Consultation Response from: KC Environmental Health (Pollution & Noise Control)		
2023/92733 Spring Grove Gardens, 50 Paul Lane, Colne Bridge, Huddersfield, HD5 0PU		
Demolition of existing buildings, erection of detached dwelling and formation of new driveway		
Date Responded: 17 November 2023	Responding Officer: MN,RM,NH	Responding Ref: WK/202333386
<p>We have reviewed the application and supporting information and make the following comments and recommendations.</p> <p><u>Noise</u></p> <p>The applicant has submitted a Noise Assessment authored by Nova Acoustics dated 15 August 2023 Ref NP-009504. A background noise survey was conducted between the 5th and the 6th of June 2023 from three measurement positions (MPs) as shown in figure 2 and a summary of the findings is shown in table 2. The acoustic environment is deemed to be low to moderate in level and the noise profile is dominated by traffic emissions from the local road network</p> <p>Figure 2 also shows the location of the Yorkshire Shooting Centre (YSC) which is located approximately 130m to the north of the proposed site. It is understood that there are 2no. dedicated external shooting areas associated with YSC at approxi

Figure 3 – Shooting Noise Level Survey

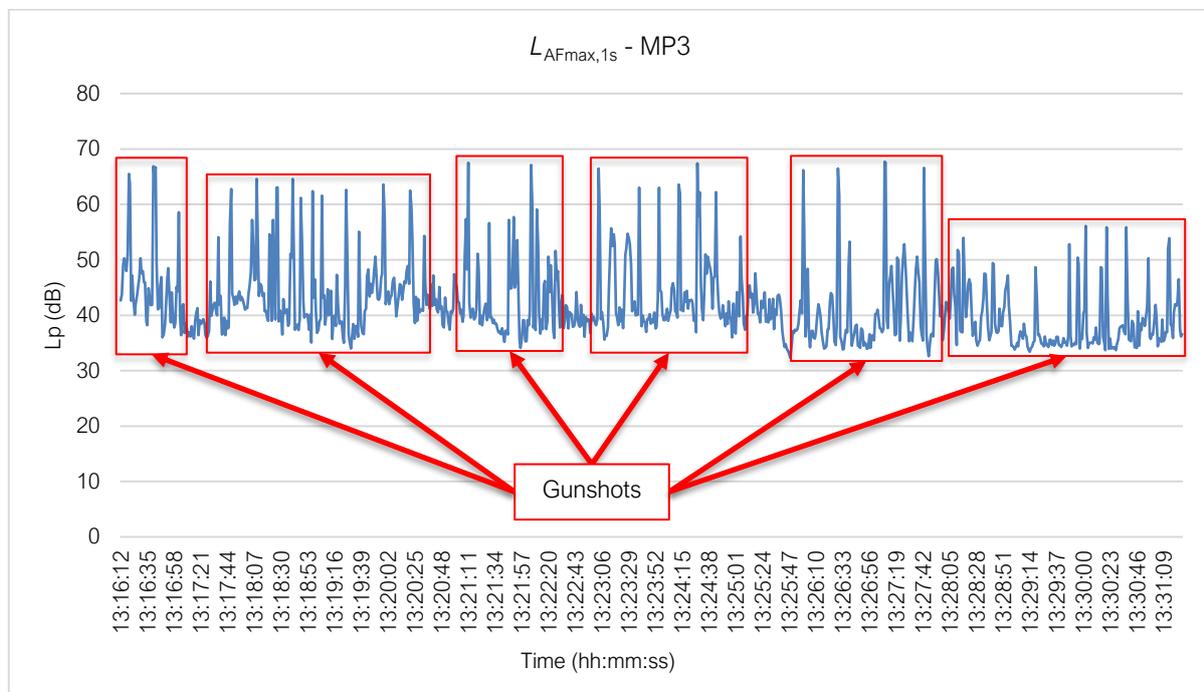
The guidelines were used to predict the level of impact in the external areas of the proposed development and figure 3 shows the L_{Amax} levels associated with the daytime use. Based upon the calculated shooting noise level, table 4 shows it is highly likely for annoyance to occur. Whilst the measurement parameters are different (L_{Amax} vs L_{Aeq}), BS8233 does recognize that the guideline values for external amenity are not achievable in all circumstances where development might be deemed to be desirable and it is for the Planning Officer to determine 'desirability'. However, the '*caveat emptor*' principle may also be applicable and it is for the buyer/current owner to determine this.

The findings of the report are accepted but a condition is recommended for a further/addendum assessment to be submitted to clarify the specification of glazing required to mitigate against daytime noise from the YSC.
